Reference No: **2023/NM/91525/E**

Site Address: 39, Latham Lane, Gomersal, Cleckheaton, BD19 4AL

Description: Non material amendment to previous permission 2022/93682 for demolition of existing garage, erection of two storey side extension, pitched roof to existing house and alterations to facade

DECISION – NON MATERIAL AMENDMENT REFUSED

PROPOSED SECTION D-D

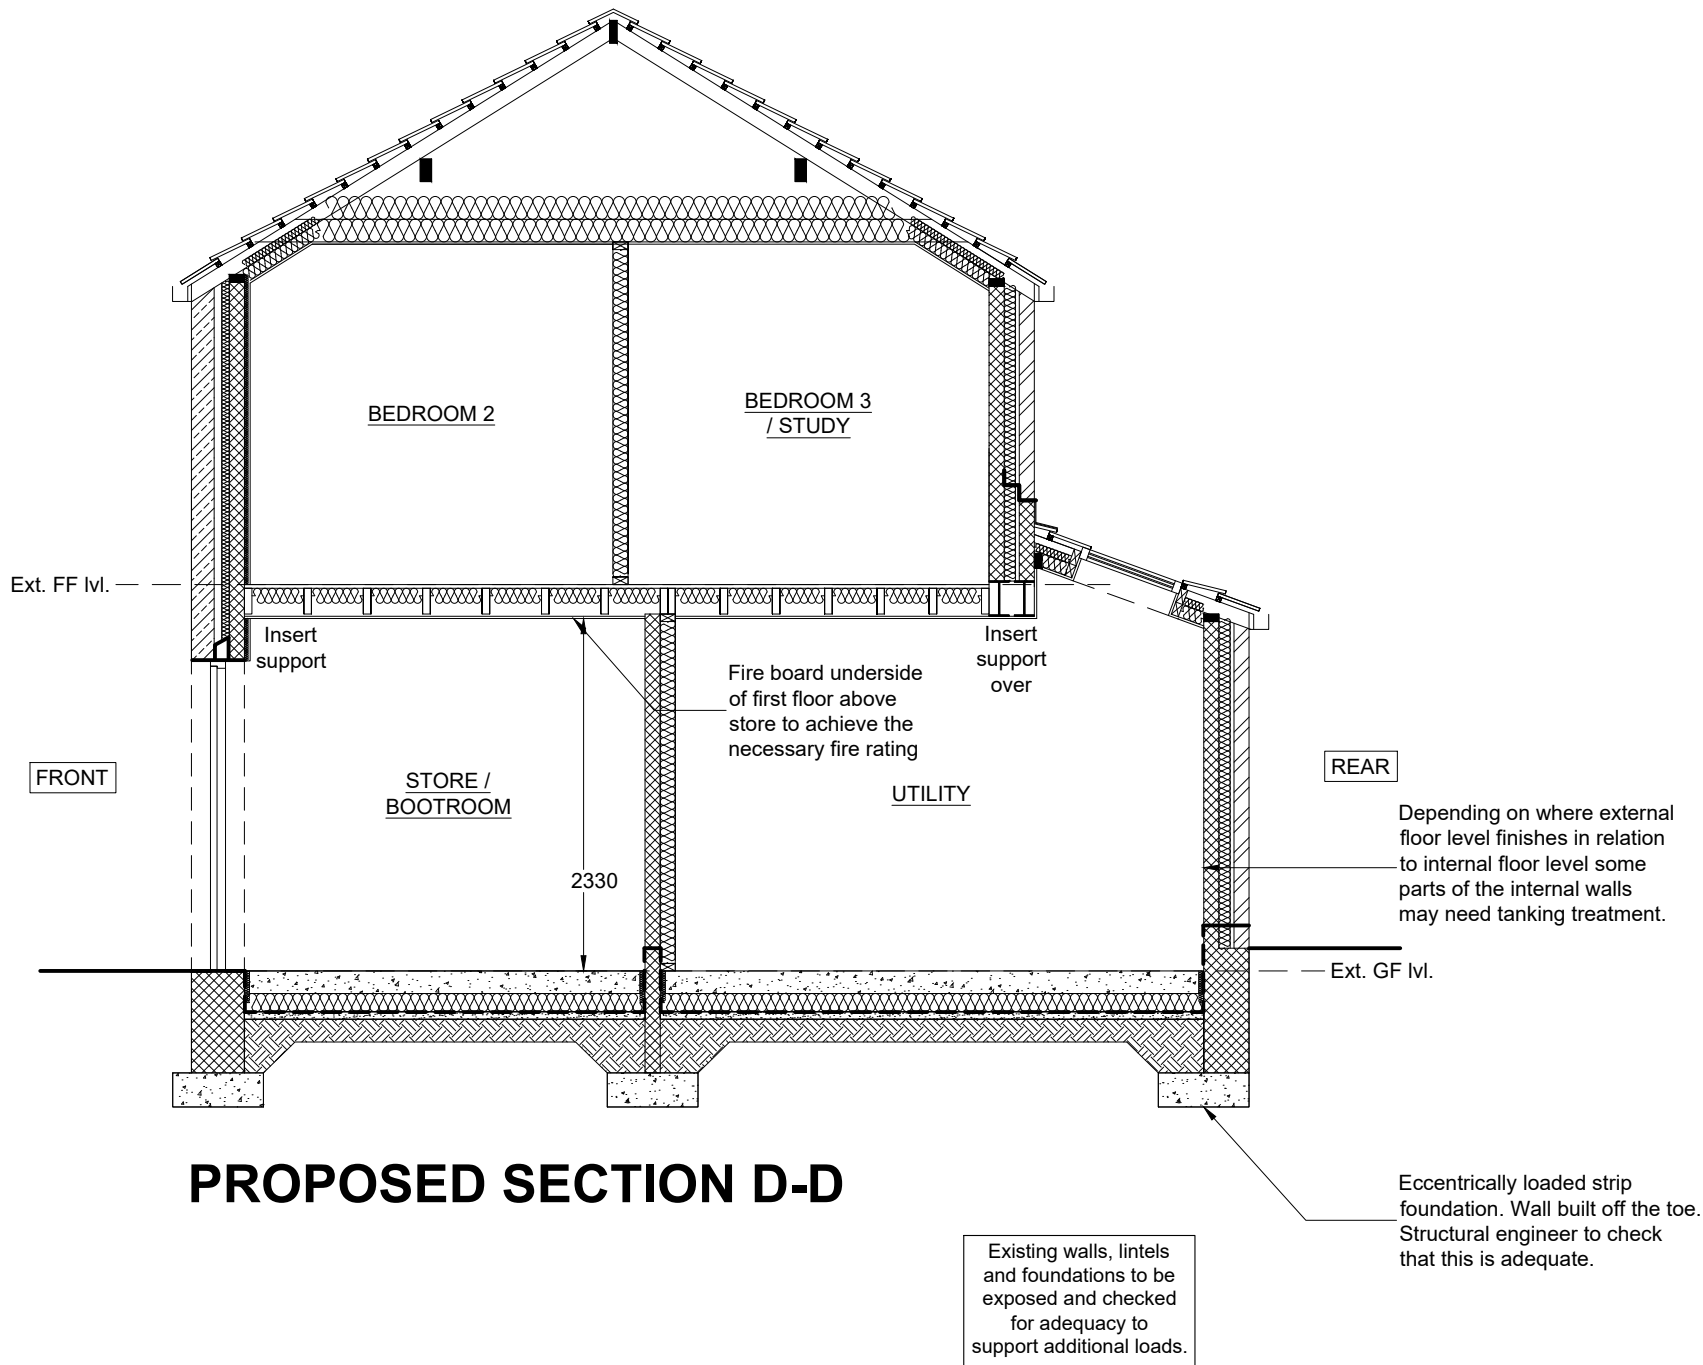
Although the proposed amendment would seek to reduce the projection of the approved two storey side extension, it is considered that cumulatively the proposed changes would amount to significant variations from the approved scheme. Therefore, it is considered that the amendment would not be inconsequential in terms of scale in relation to the original approval.

Whilst the submitted plans indicate that the changes would alter the appearance to a degree, it is considered that the proposed amendments would not result in a material change in the external appearance and would be acceptable. The plans demonstrate that a new principal first floor window would be installed to the south-facing side elevation to reflect the changes to the internal layout. It is noted that the window would serve a bedroom which is a habitable room and would face onto the gable end of the neighbouring property. Given that the window would have a restricted outlook, it is considered that the change would have a detrimental impact upon the living conditions of the occupiers of the host property.
